**Consultation Response from KC,
Trees****2020/93954 Land at, Lingards Road, Slaithwaite, Huddersfield, HD7 5HY****Erection of 42 dwellings and associated works****Date Responded: 8/6/22****Responding Officer: Nick Goddard****Responding Ref:**

| SITE PLAN 2                                                                                                           |          |            |  |

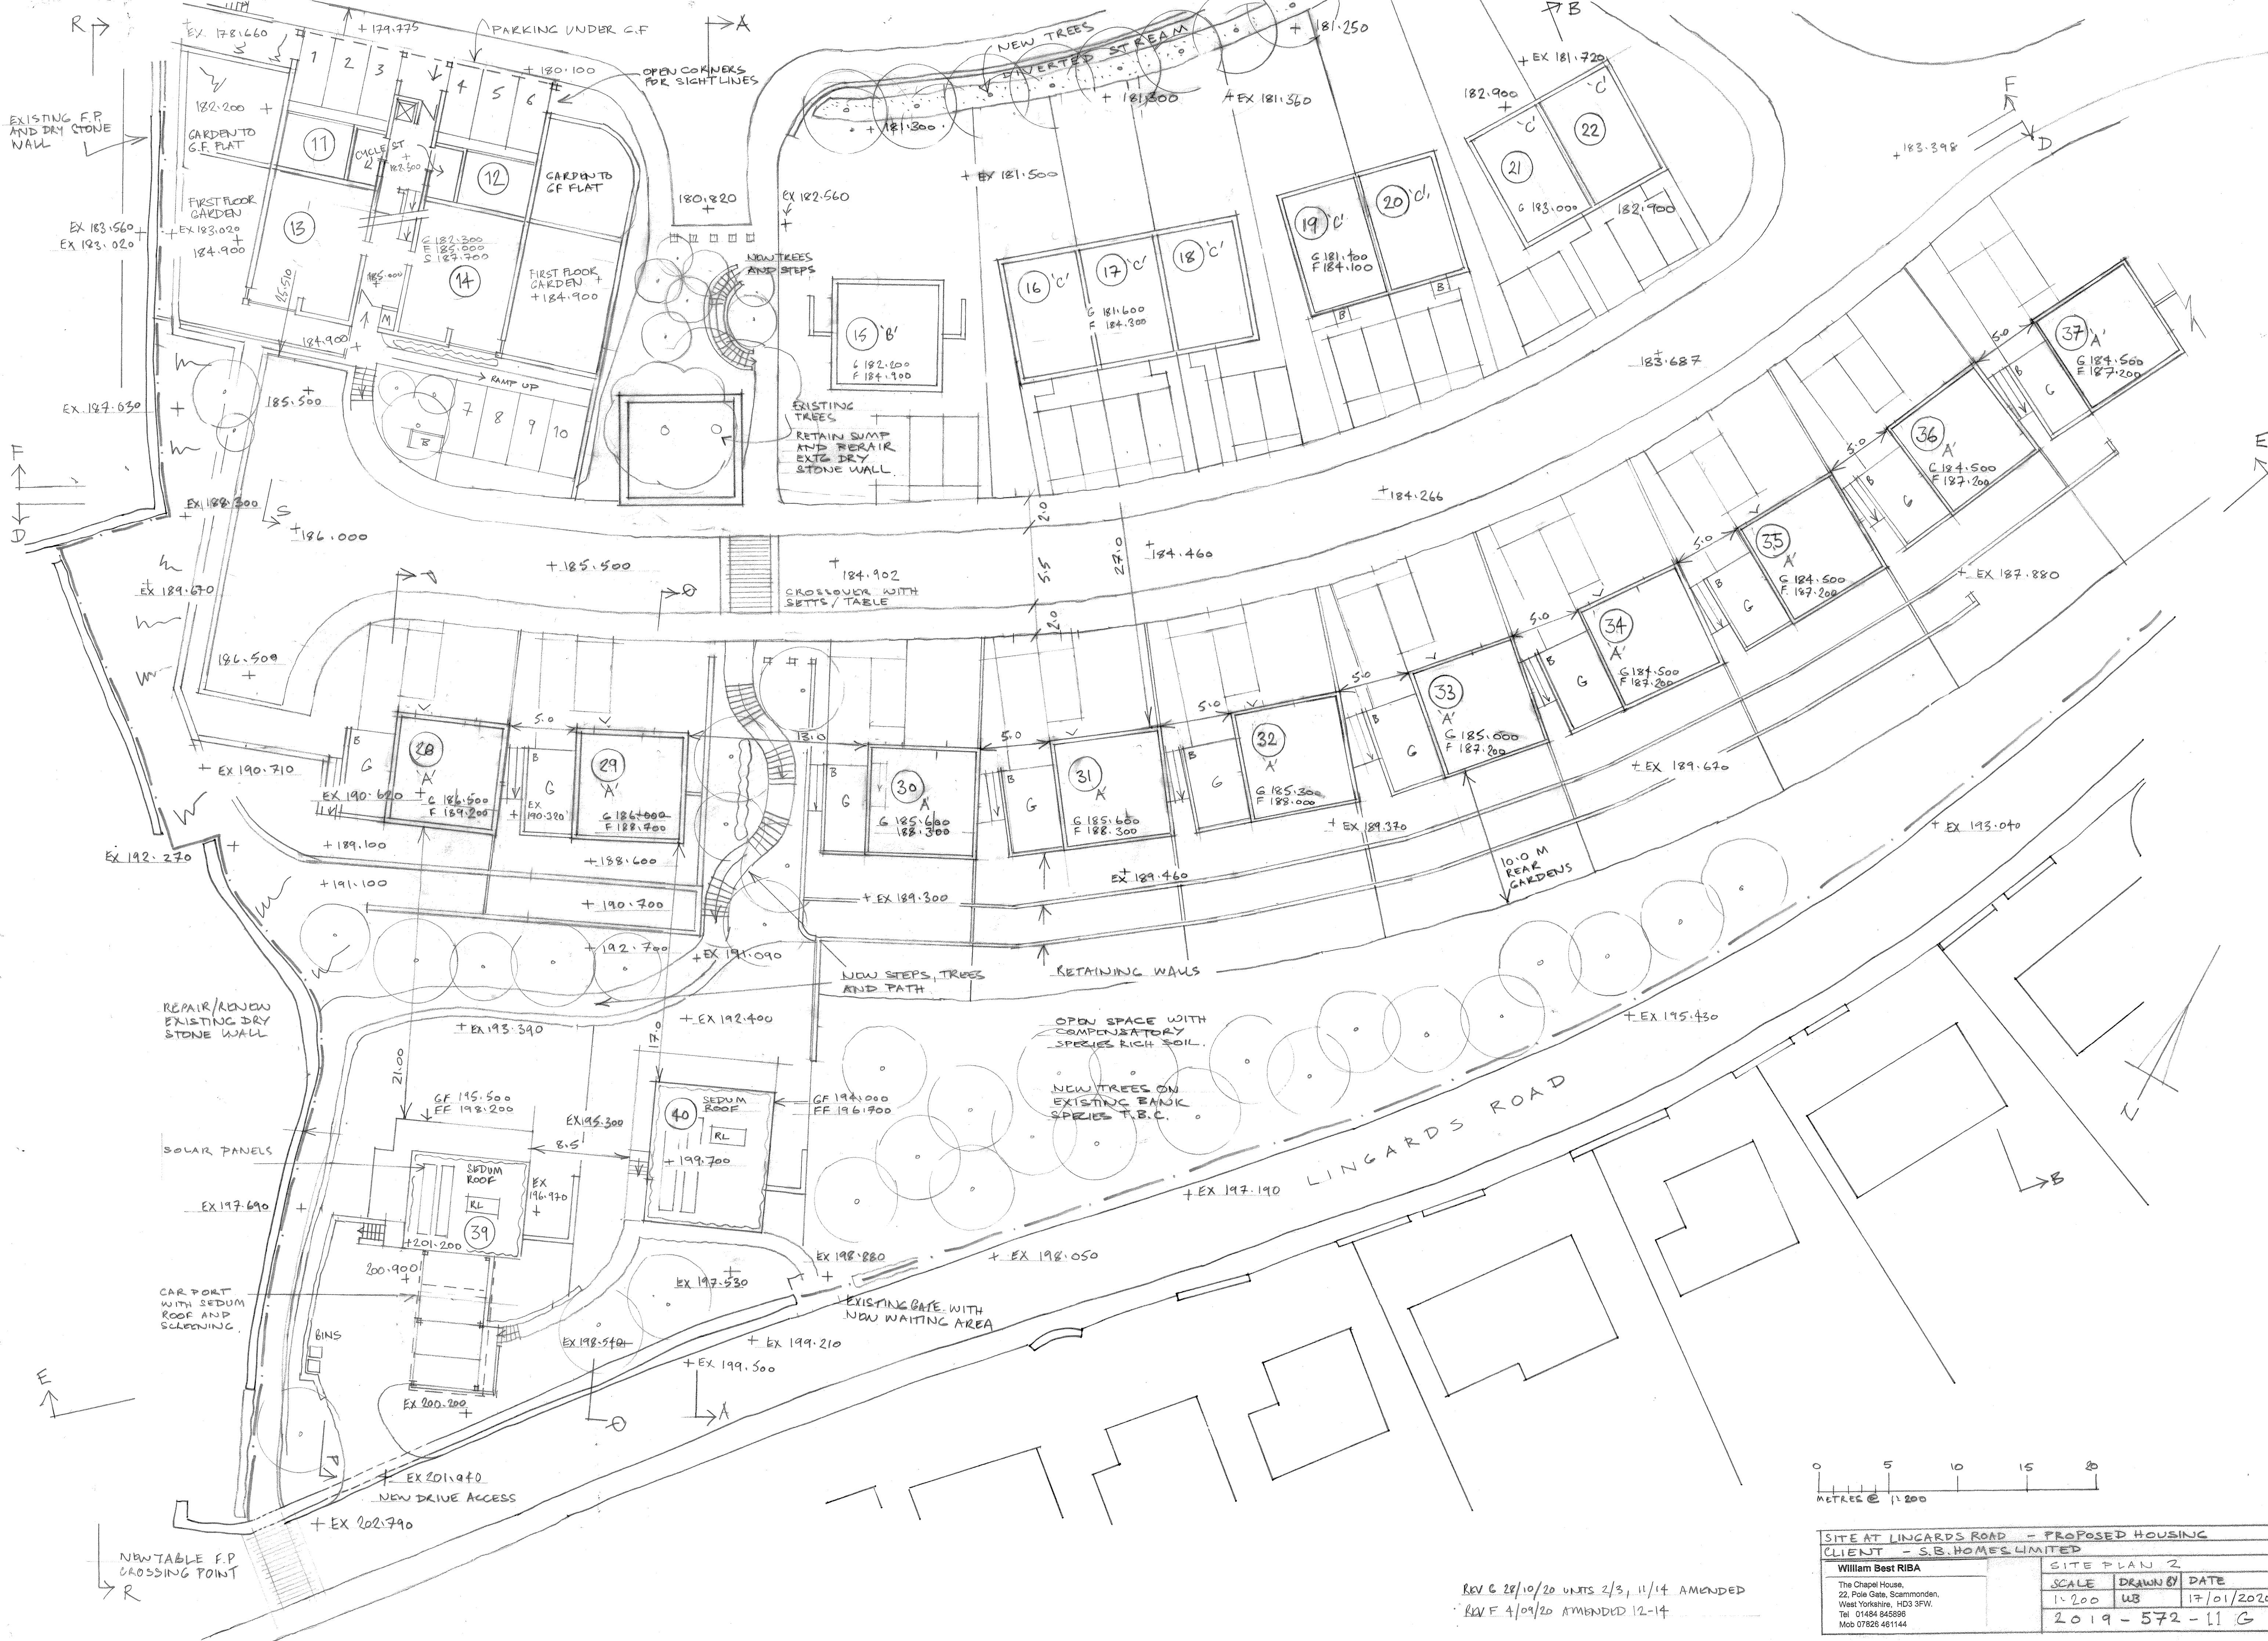
The trees within the site have been retained and consideration has been given to the ground levels to enable this to be possible. There is however still a lack of suitable tree information and an Arboricultural Method Statement and Tree Protection Plan will need to be provided to reassure that the proposed levels and required tree protection will be compatible.

The proposals provide indicative locations of tree planting however there is a marked lack of detail regarding the soft landscaping. Street tree planting is now expected on sites of this scale however this stie was submitted prior to this being introduced to the NPPF but that should not prevent the development from providing a high quality landscaping scheme to improve the tree cover and bio-diversity of the site.

SITE PLAN 1	
SCALE	DRAWN BY DATE
1:200	WB 17/01/2020
2019-572-10 G

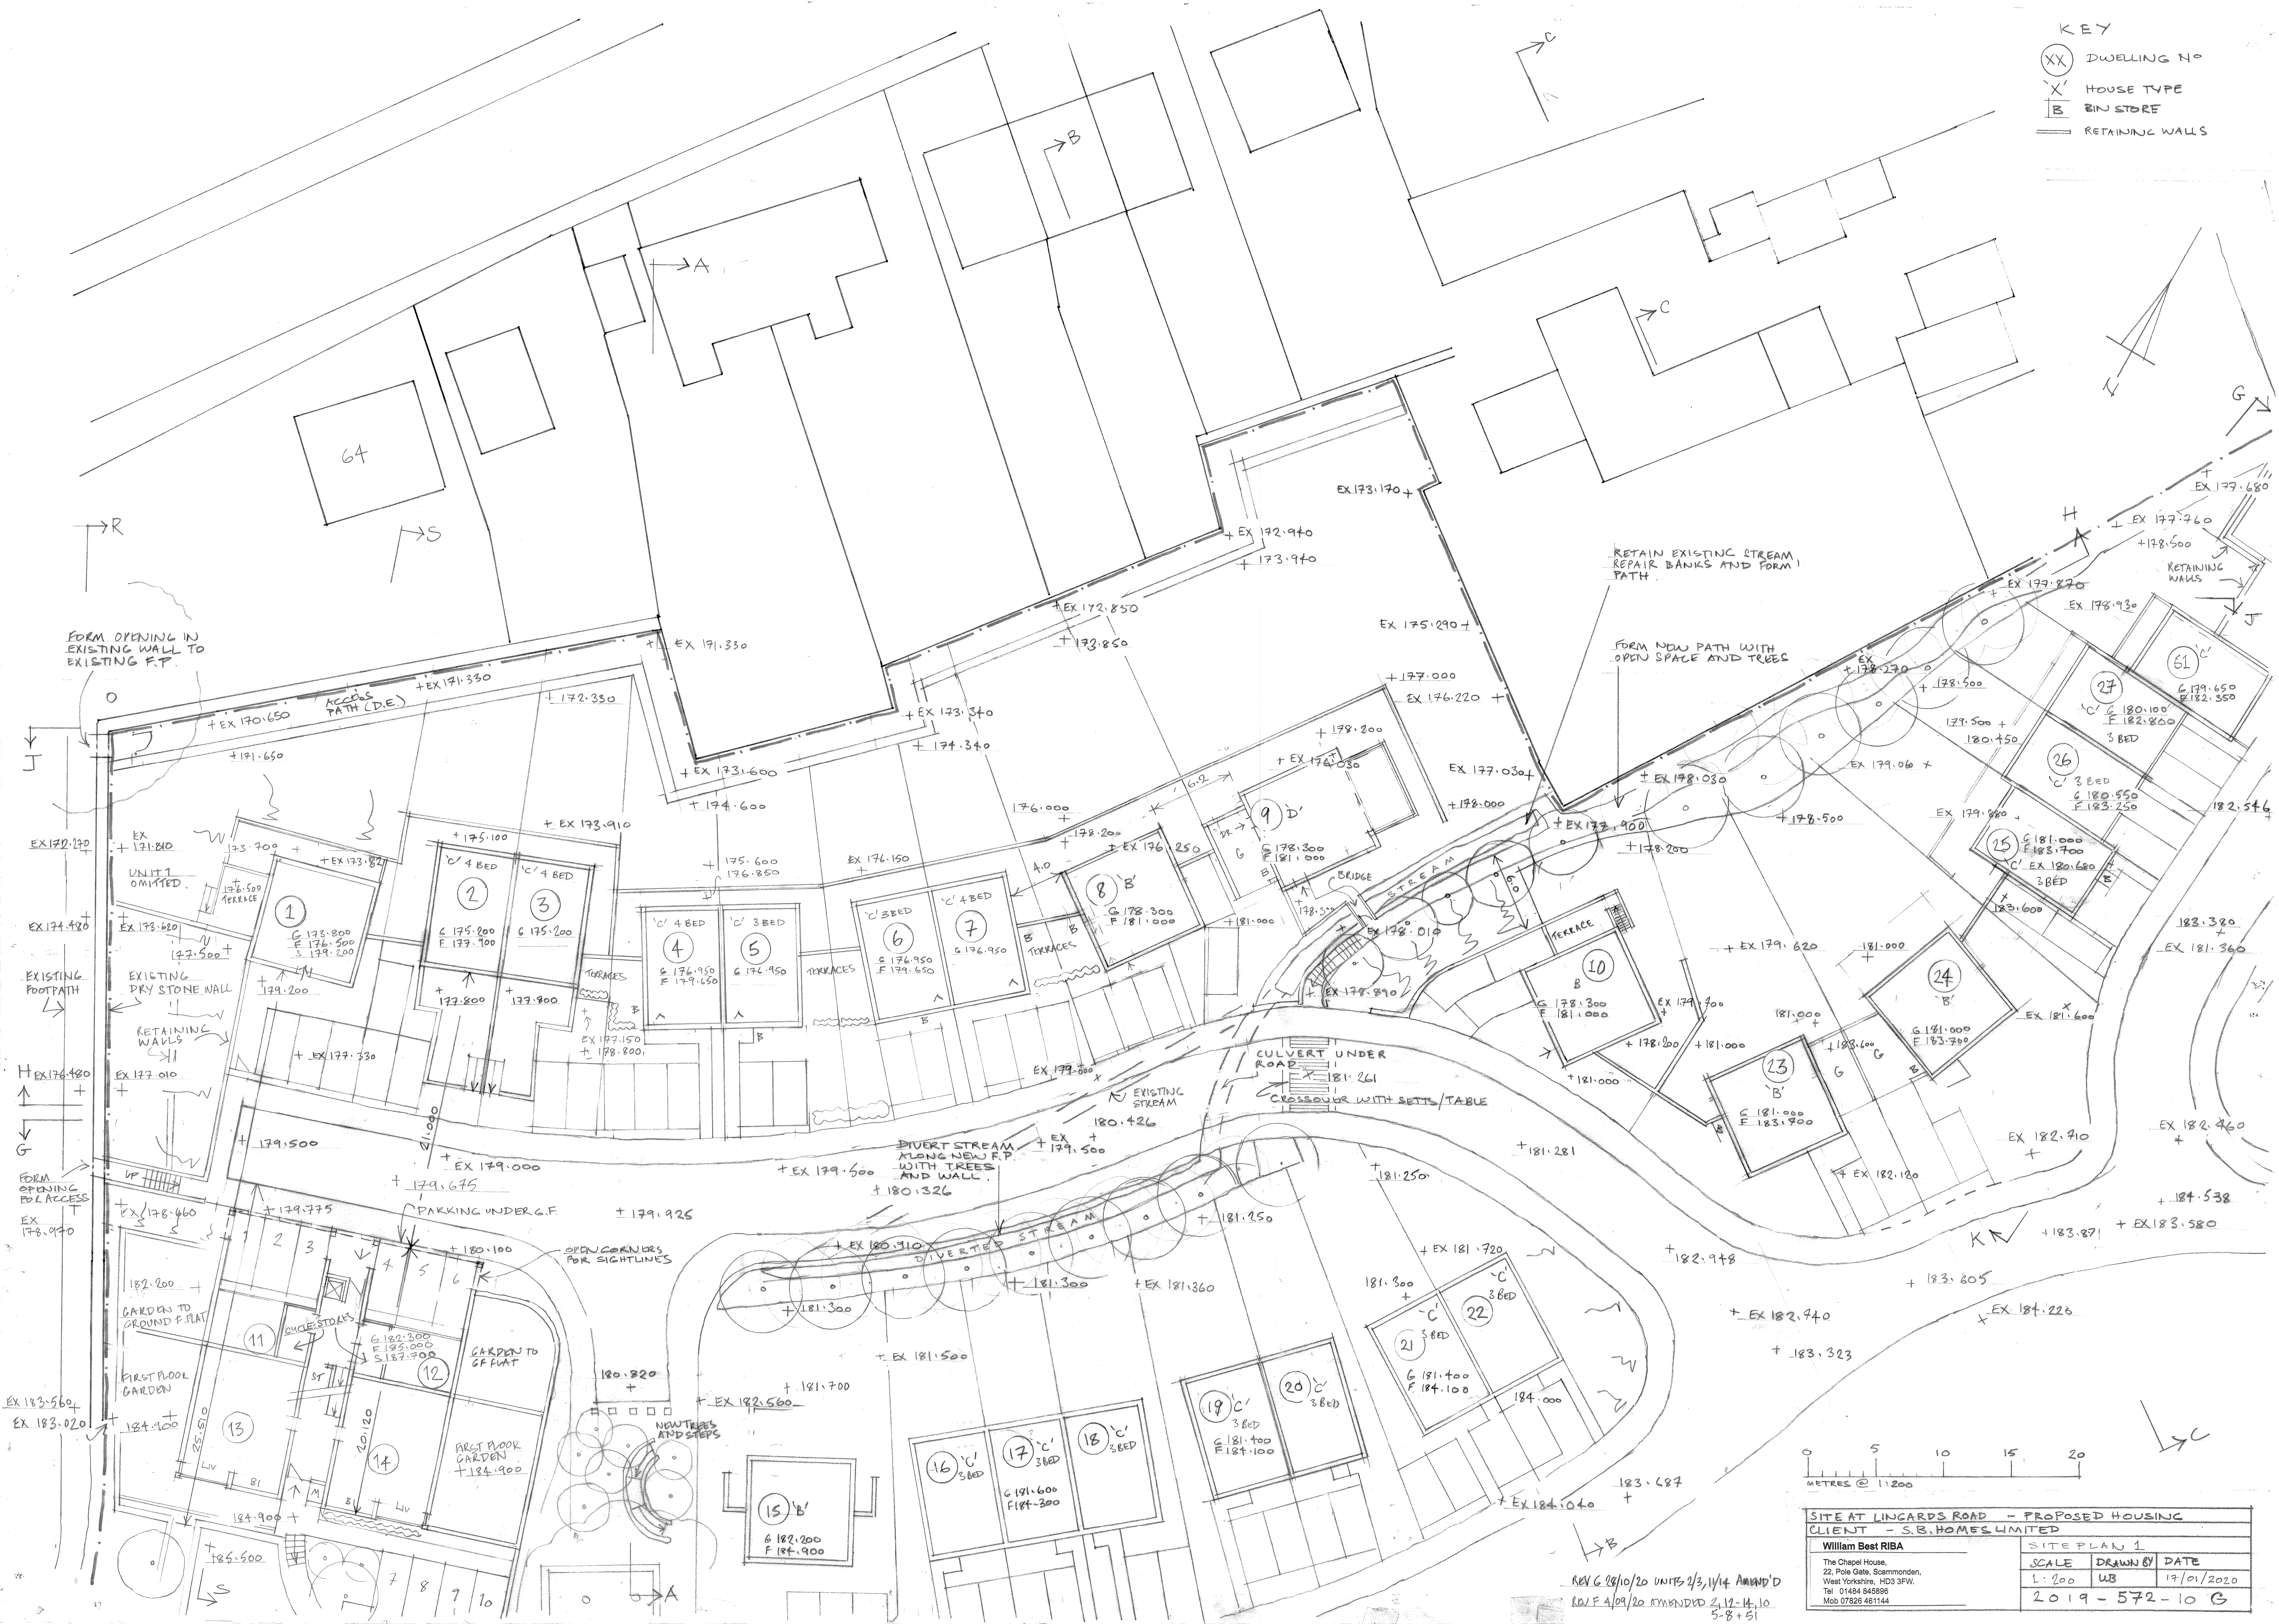
The proposals have been amended to take into account previous concerns about drainage impacting on trees adjacent to Manchester Road. This is a significant benefit to this revised layout as the trees along Manchester Road provide a high level of public amenity value.
